**The M4 Motorway (Junctions 3 to 12) (Smart Motorway)  
(Amendment) Order 2022**

An application has been made under paragraph 2 to Schedule 6 of the Planning Act 2008(a) to the Secretary of State in accordance with the Infrastructure Planning (Changes to, and Revocation of, Development Consent Orders) Regulations 2011(b) for a non-material change to the M4 Motorway (Junctions 3 to 12) (Smart Motorway) Development Consent Order 2016(c).

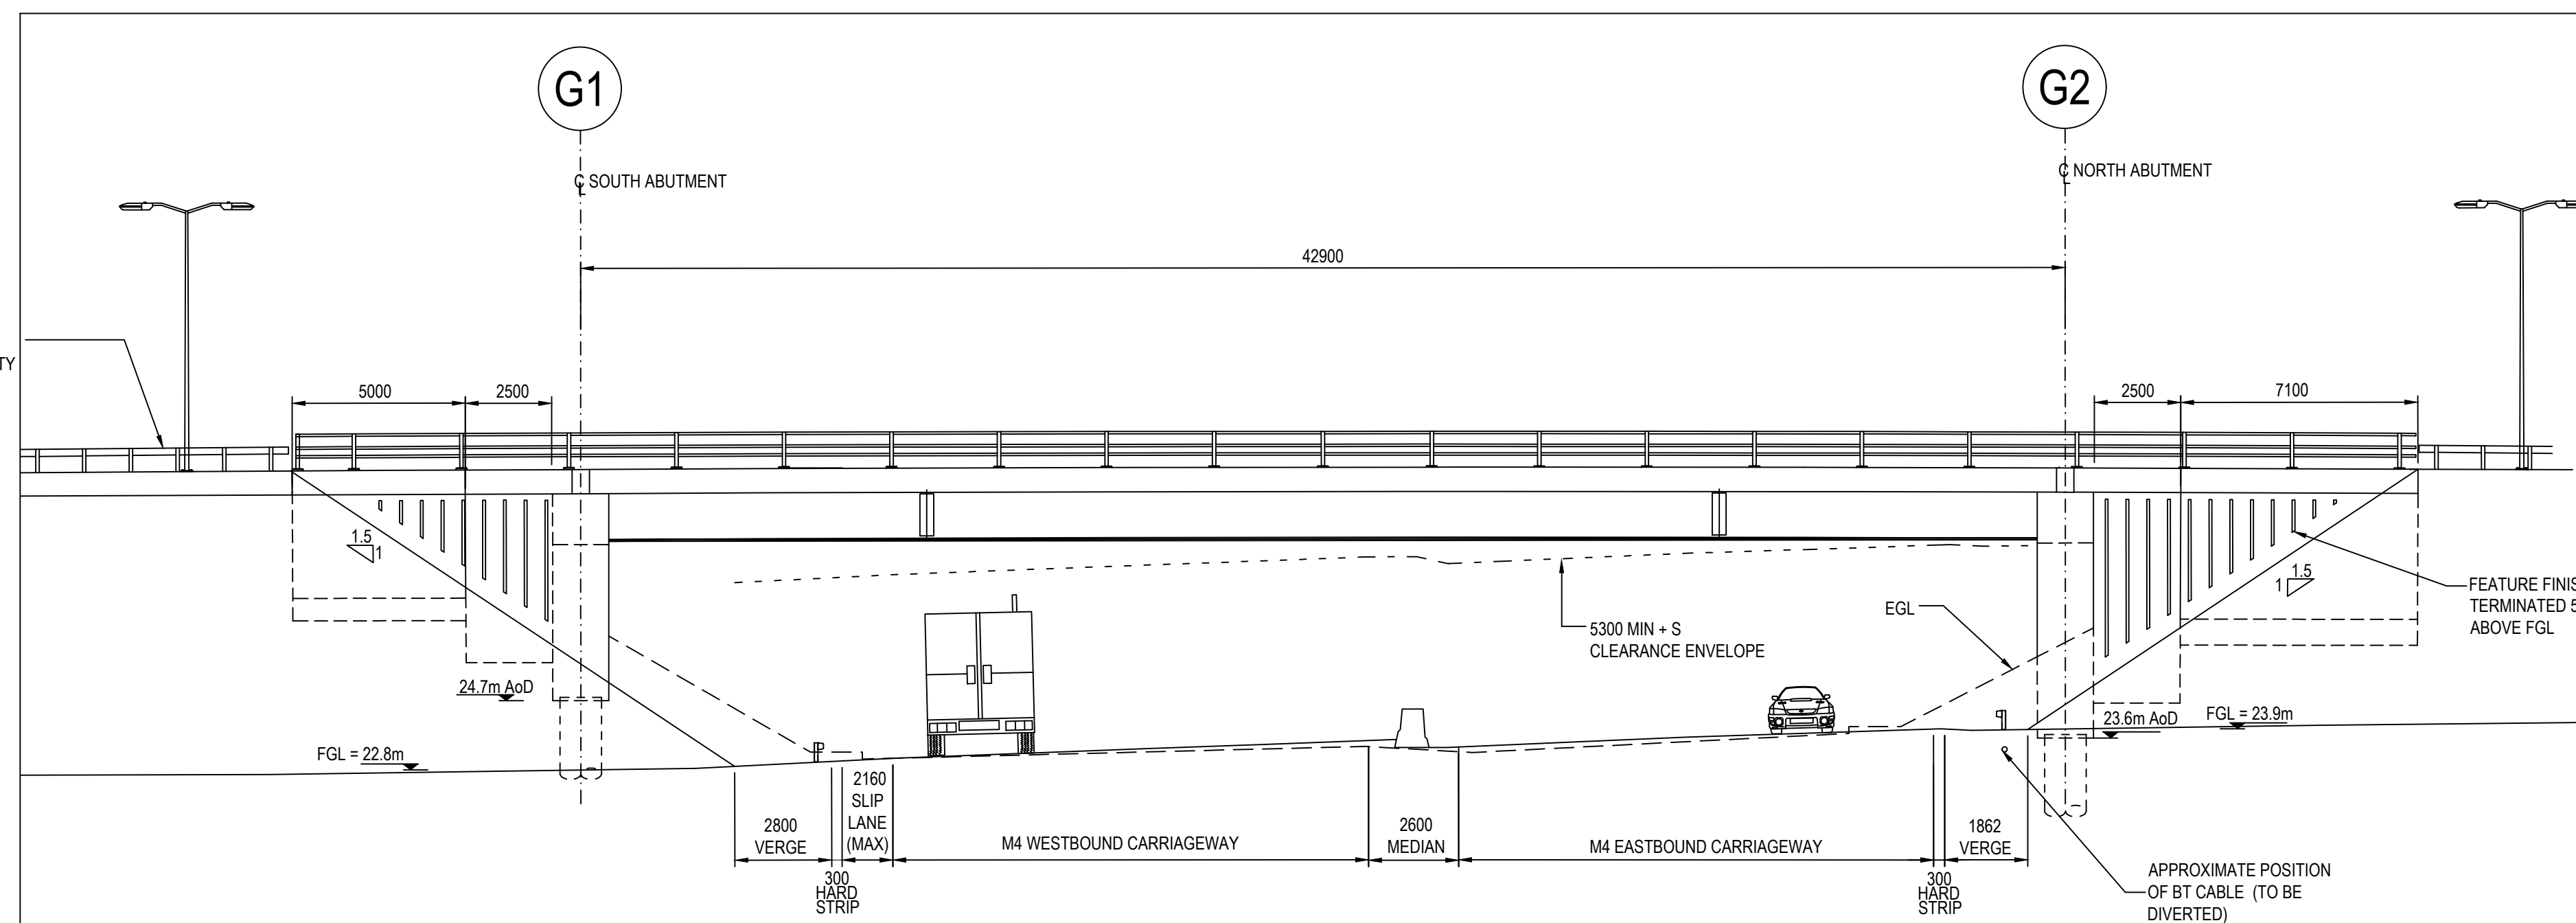
(a) add the words “single online single span” before the word “bridge”;

(b) add the words “northbound and” before “southbound”;

(c) delete “to the east of the existing Huntercombe Spur overbridge”; and

(d) delete “construction of a new bridge for the northbound carriageway of the Junction 7 Link Road (Huntercombe Spur) over the M4”.

PLAN OF PROPOSED WATER AND GAS MAIN SUBWAY ARRANGEMENT
SCALE 1 : 100

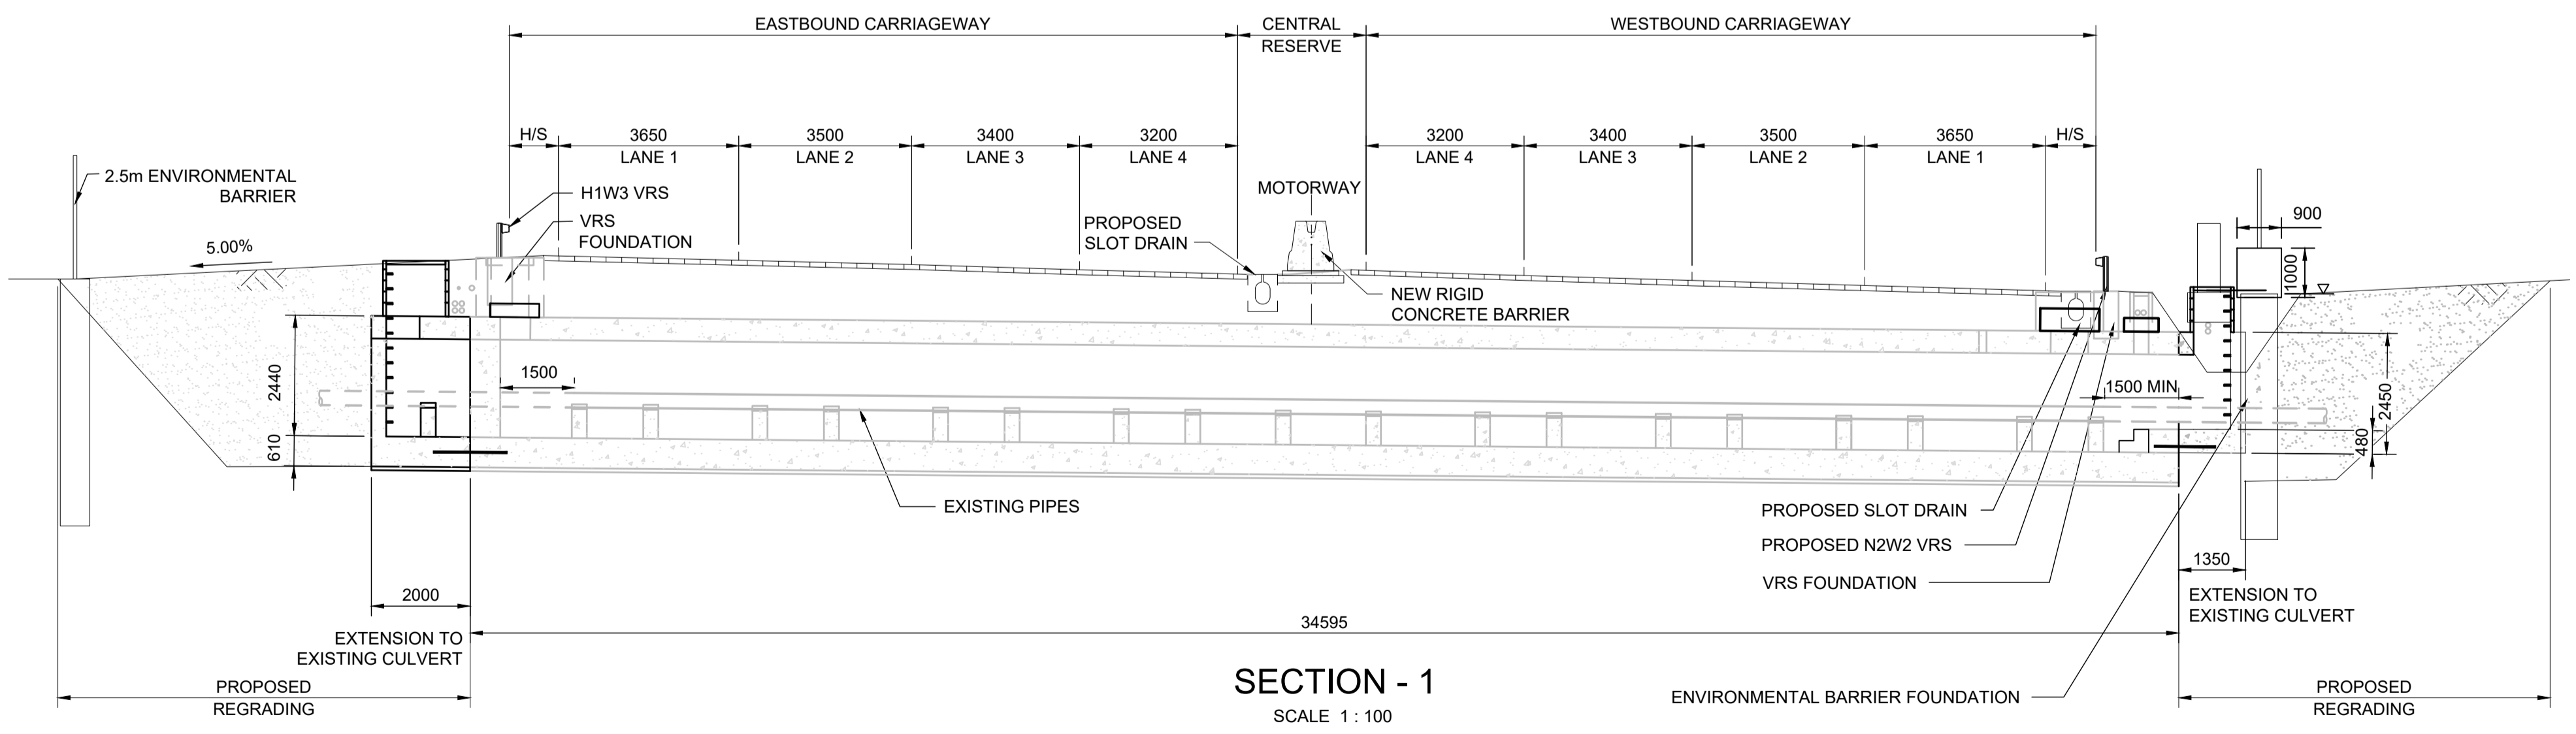
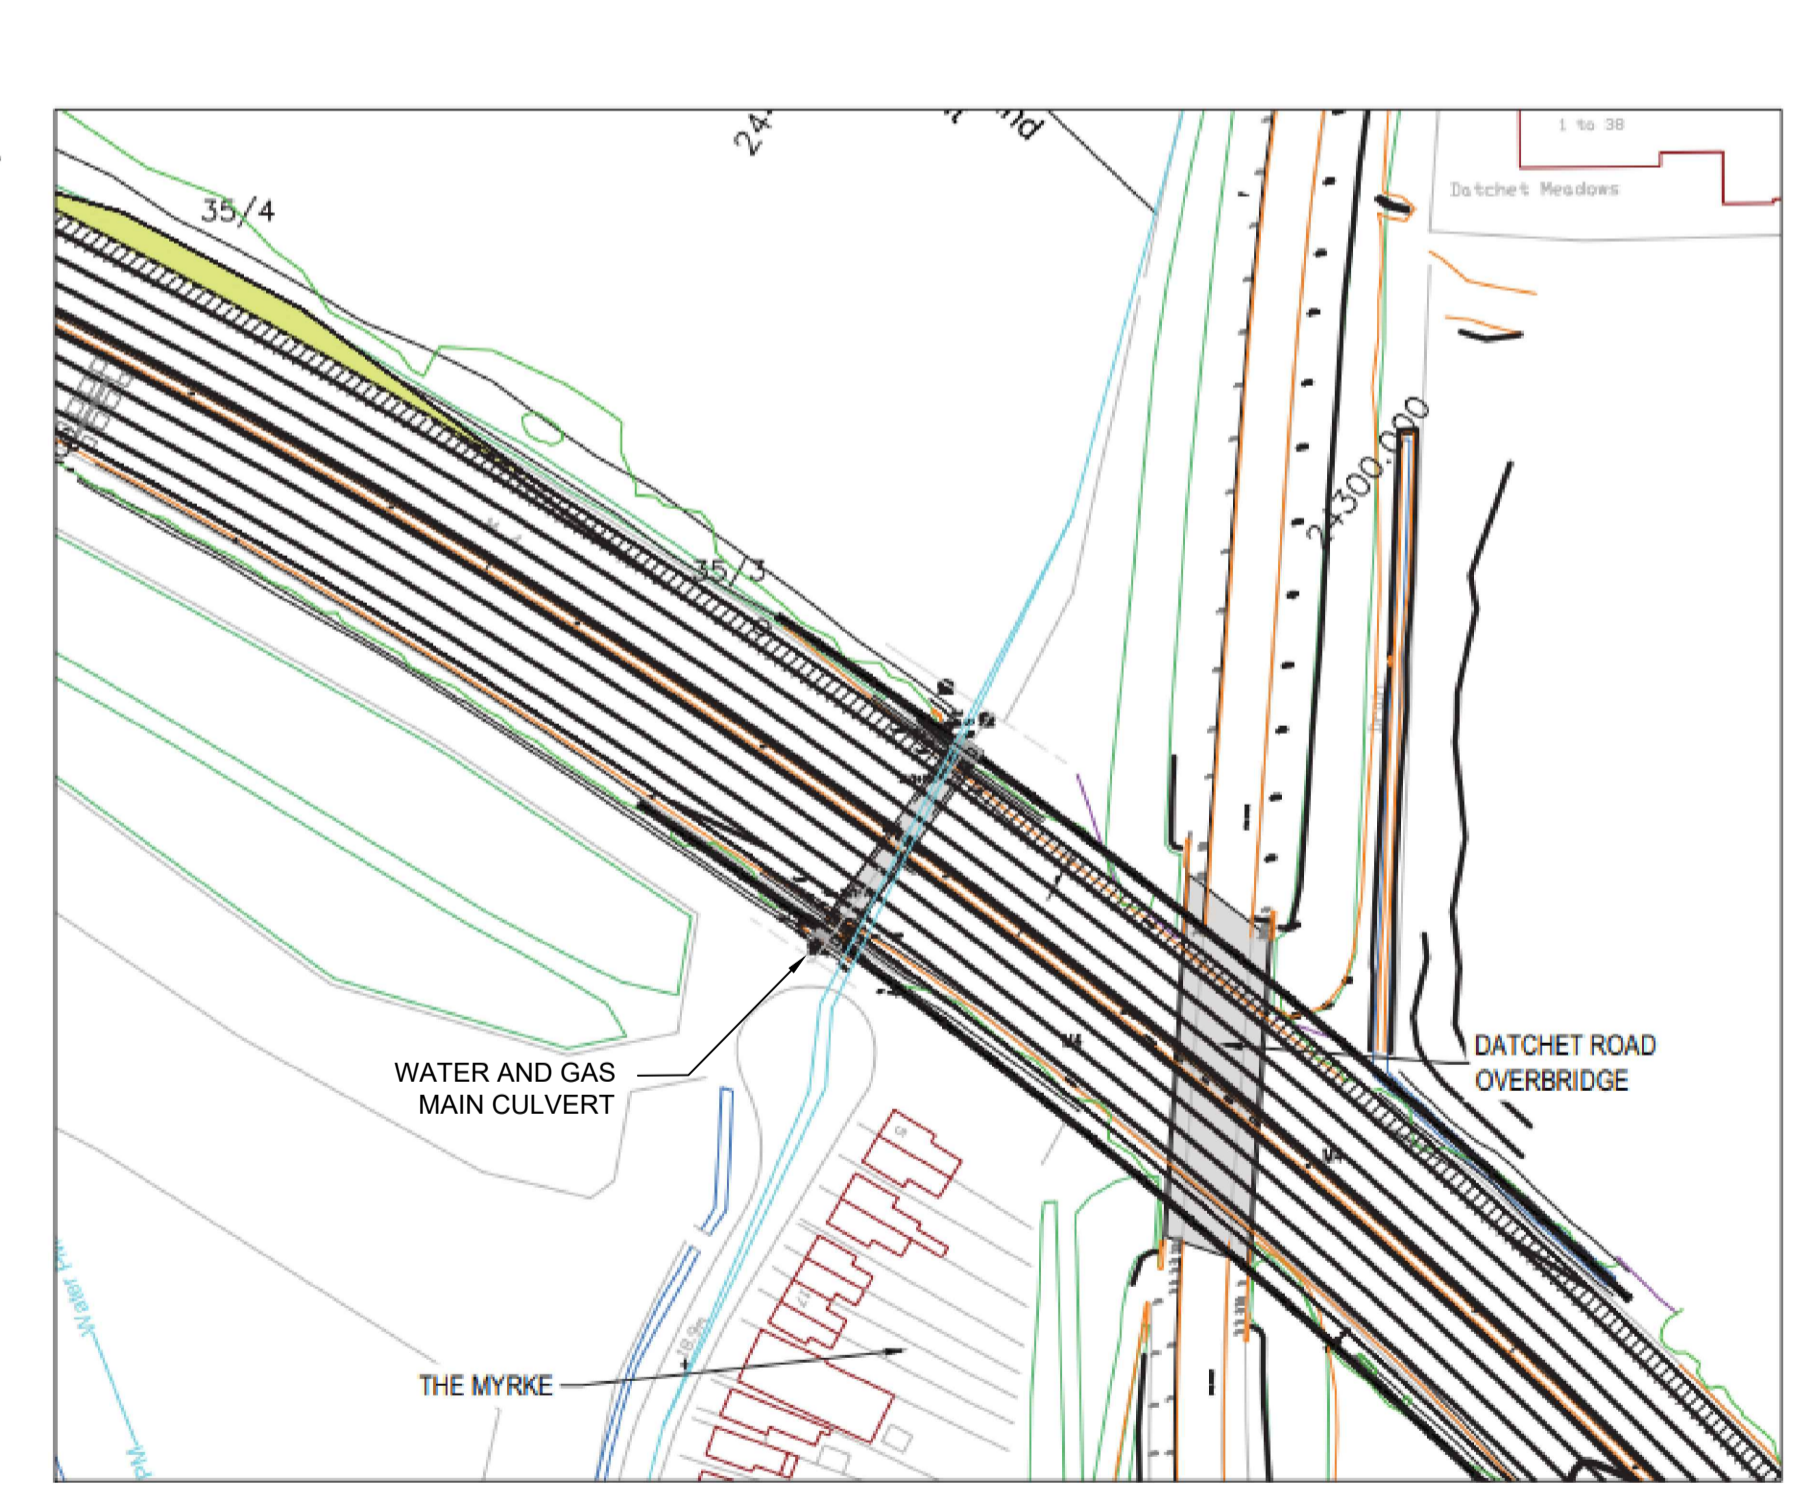
(13) In Work No. 21 substitute “extension” with “widening” before “of the water main subway”.
